PLANNING OBJECTION — RISK TO PUBLIC DRINKING WATER SUPPLY

Re: Briskalagh Renewable Energy Development – Further Information & Additional Works
Planning Authority Case Ref: 2560003

Submitted on behalf of the Kilkenny West Group Water Scheme

Drawn By MC	Checked By EMC
Project No. 230502	Drawing No. Figure 4-2
Scale 1:13,000	Date 2024-09-09

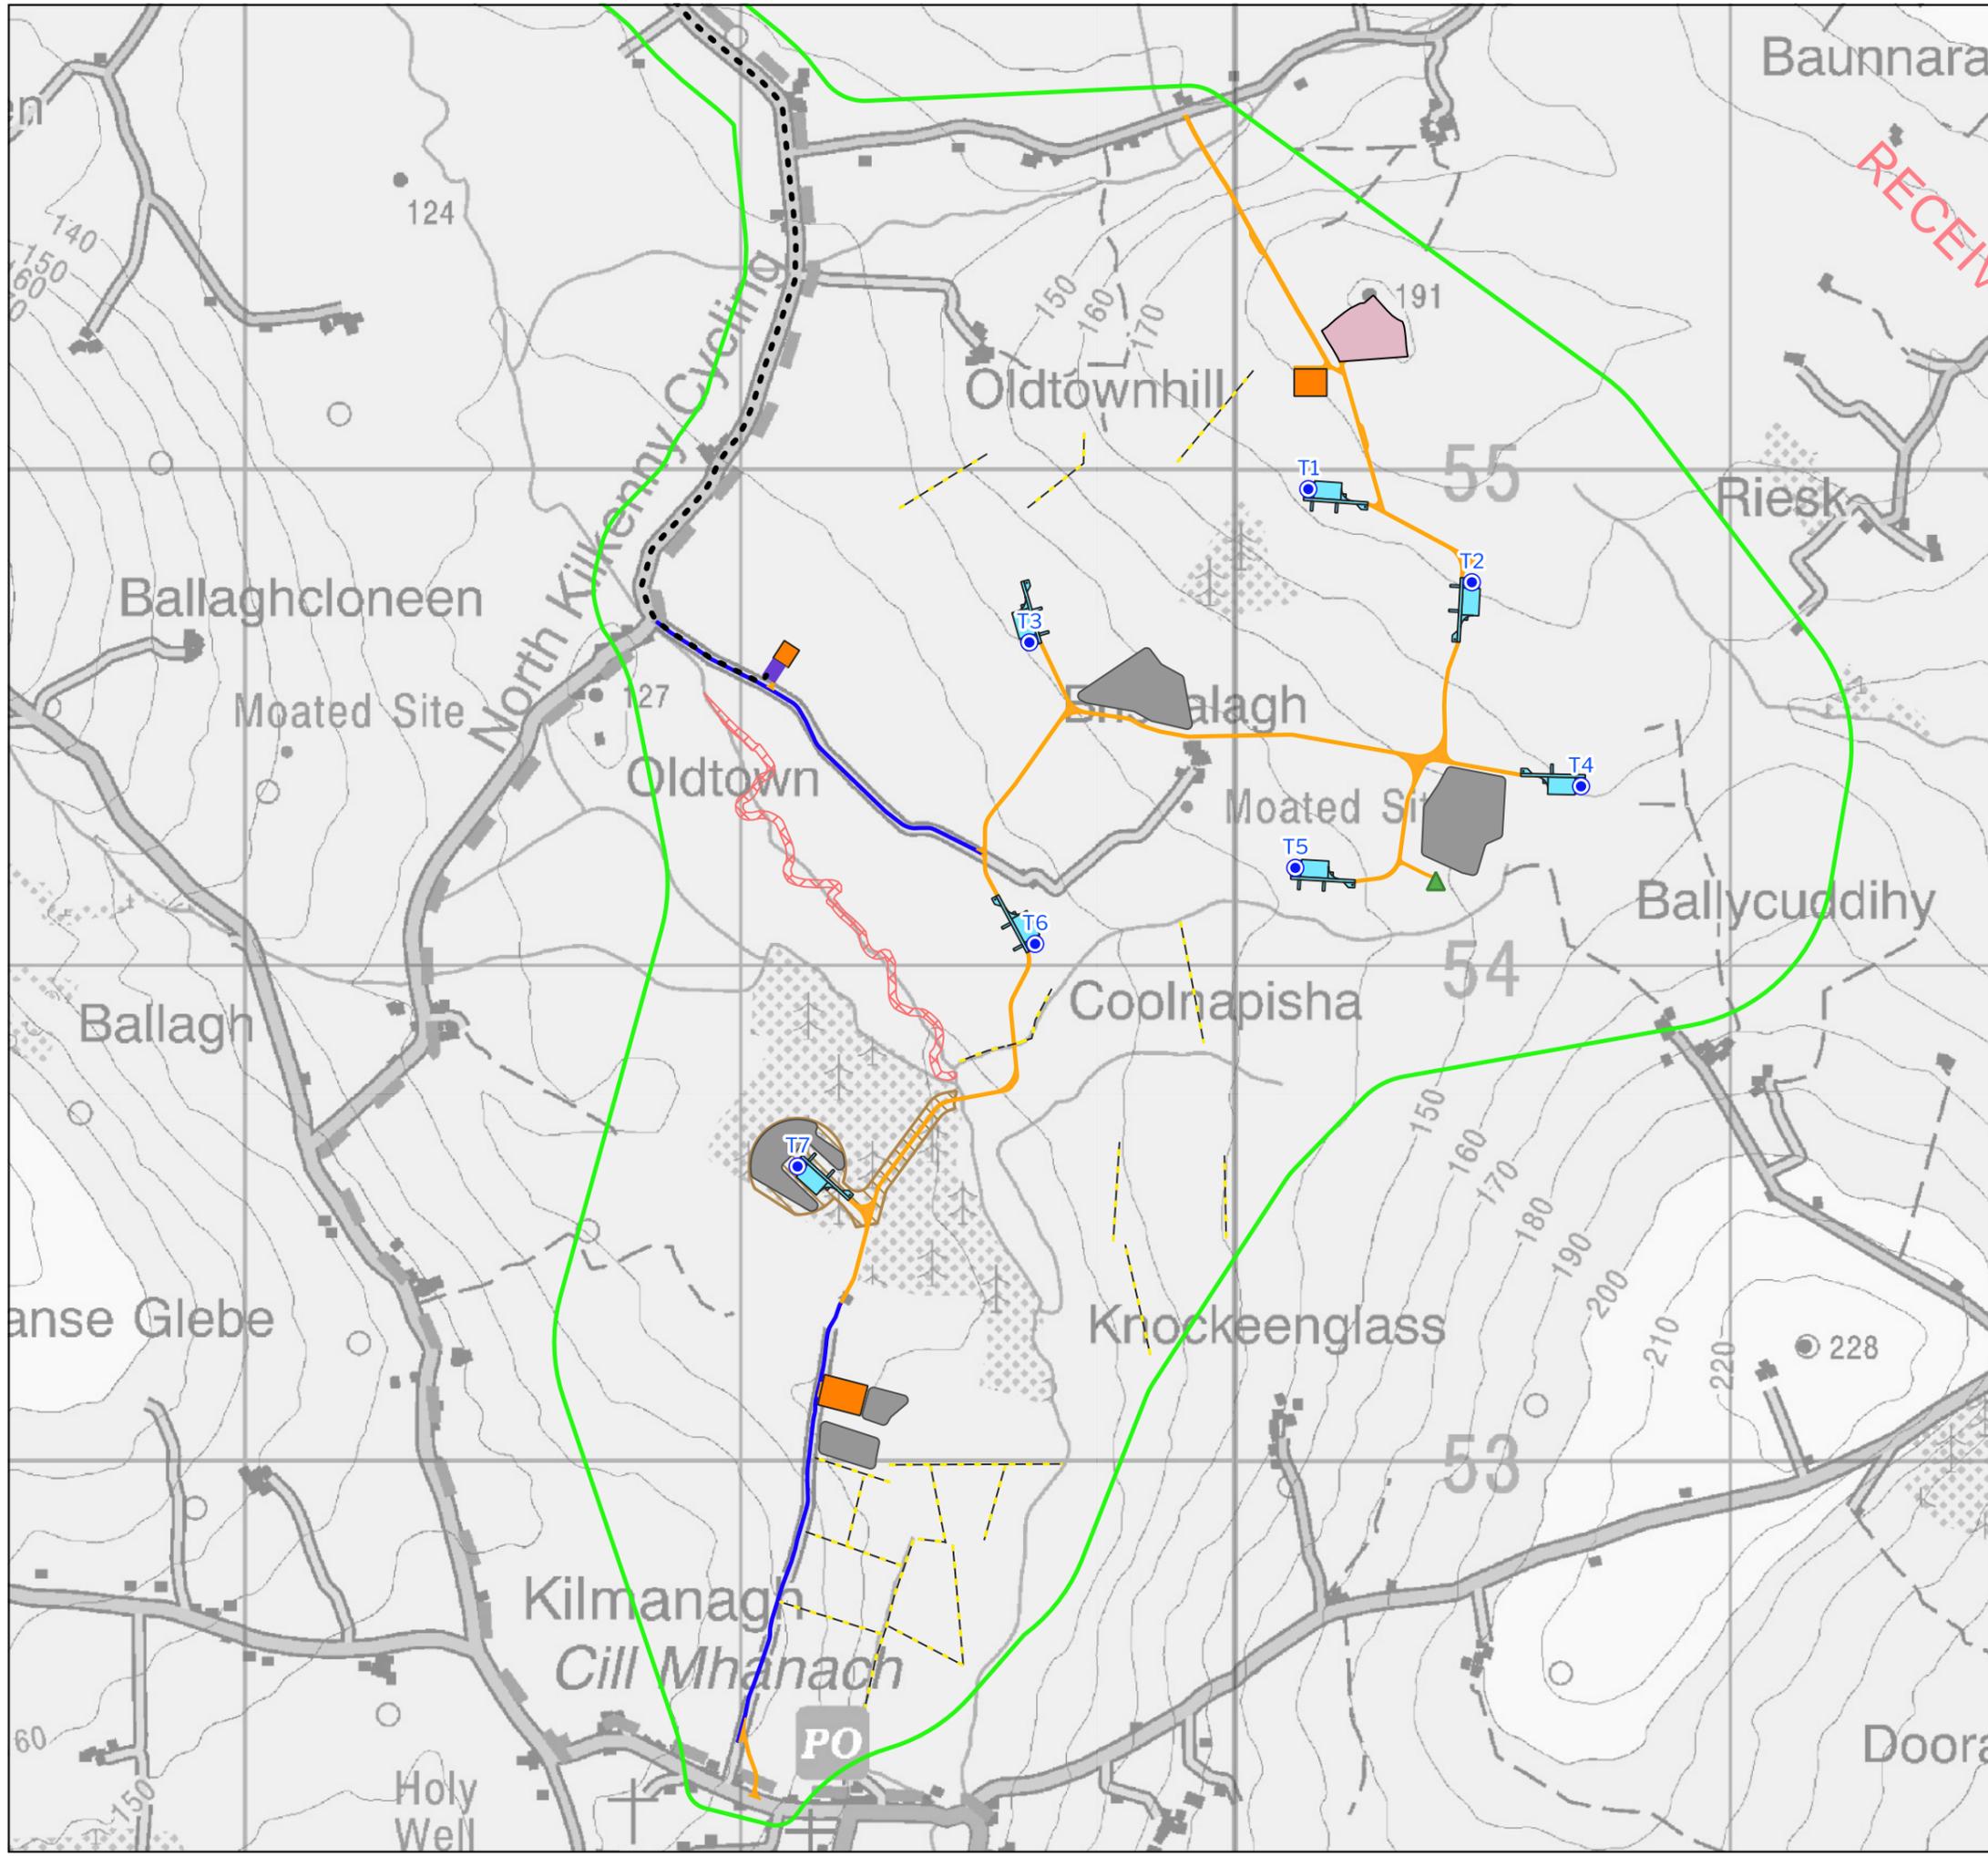
- Turbine foundation excavation
- Crane hardstand construction
- New access road construction
- Cabling trench installation
- Temporary construction compound immediately adjacent (EIAR Chapter 4, Figure 4-2)

continuing with T07 and its associated compound, access road, and cabling works represents a **foreseeable, preventable and disproportionate risk to public health**.

- A) **Planning permission be refused**, on the grounds of unacceptable drinking-water risk, **OR**
- B) At minimum, the development be **modified by removing T07 and all associated infrastructure and earthworks**, including hardstands, compound, access roads and cabling trenches located in the TP14 gravel-aquifer zone, **OR**
- C) An **independent hydrogeological risk assessment** be required that specifically tests whether construction at T07 could impact the Ballycallan abstraction under **worst-case rainfall and waterstrike conditions**.
